Reference: RA-2024-147502/07
Customer reference: 2024/0580
21 April 2026

Hybrid planning application comprising: a) Full planning application for 250no dwellings together with attenuation basin and temporary access route, landscaping and associated works at Area 1; and b) Outline planning application with all matters reserved for up to 200no. dwellings on Area 2 (AMENDED RED LINE BOUNDARY AND PLANS).

Land south of Doncaster Road and adjacent to Strawbridges Garden Centre, Darfield, Barnsley, S72 5EZ

Environment agency position

Fig 3 – Flood Zone Extents Adjacent Proposed Detention Basin

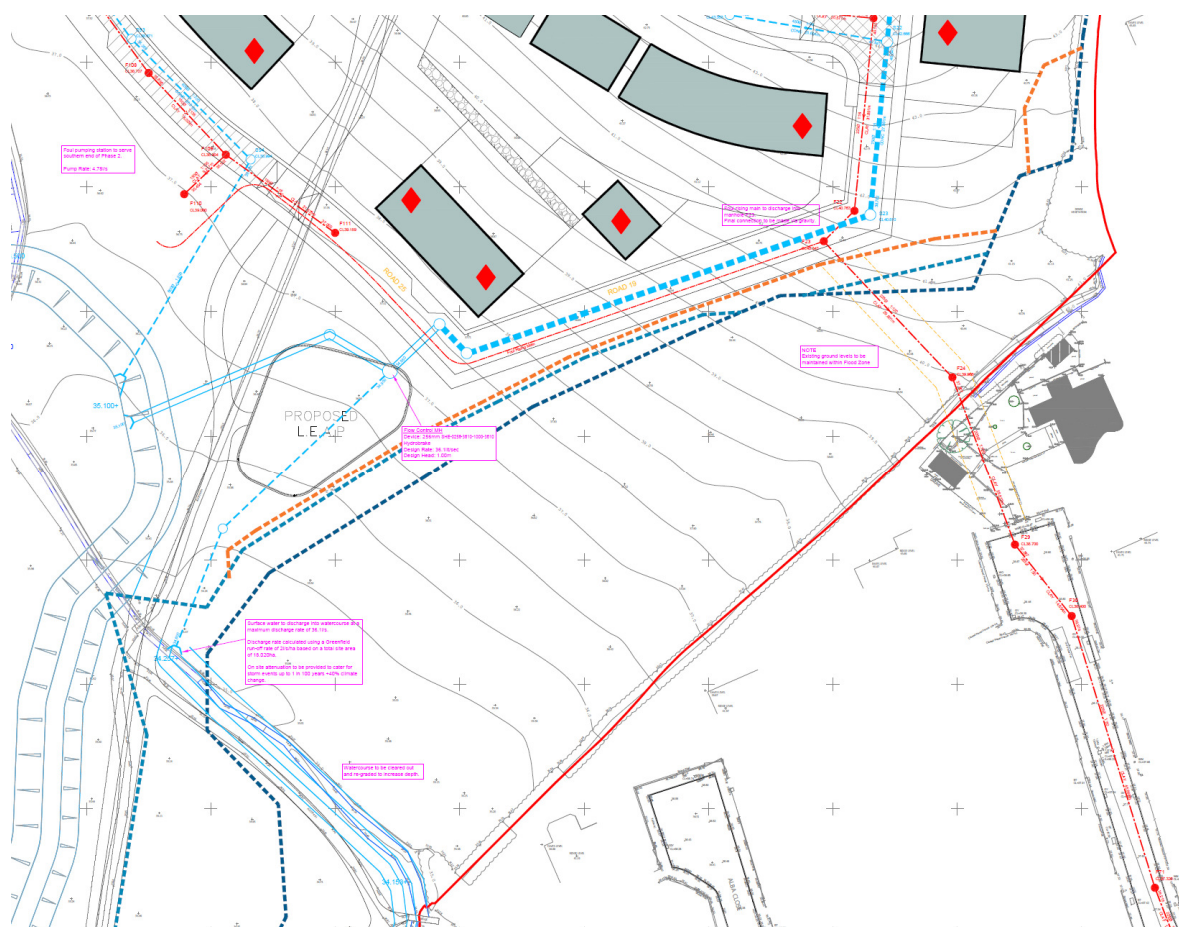
We note that the updated development plans show that the attenuation basin is now located further to the west outside of flood zones 2 and 3. However, we note that there are still works proposed which may have an impact on fluvial (river) flood risk, namely the rerouting of the watercourse around the basin to the west and the regrading of the existing watercourse in the east (including the introduction of a surface water outfall (and ground level raising) in flood zone 2 into the proposed diverted watercourse).

In the absence of an adequate flood risk assessment (FRA) we object to this application and recommend that planning permission is refused.

Identify the 1% AEP + CC fluvial (river) design flood level and demonstrate that the proposed development doesn't increase flood risk. Measures should include:

- Finished floor levels no lower than 600mm above the designed flood level.
- Ensure the proposed development does not increase offsite flood risk by displacing flood water during fluvial flood events.
- Evidence the proposed watercourse rerouting and regrading do not increase offsite fluvial flood risk by displacing or re-routing flood water.
- Demonstrate that site users have a safe means of access and egress up to and including the fluvial design flood event.

Any compensatory storage required due to displacement of fluvial flood waters or restriction of flows in the river channels must be located outside of the 1% plus climate change flood event flood extent.
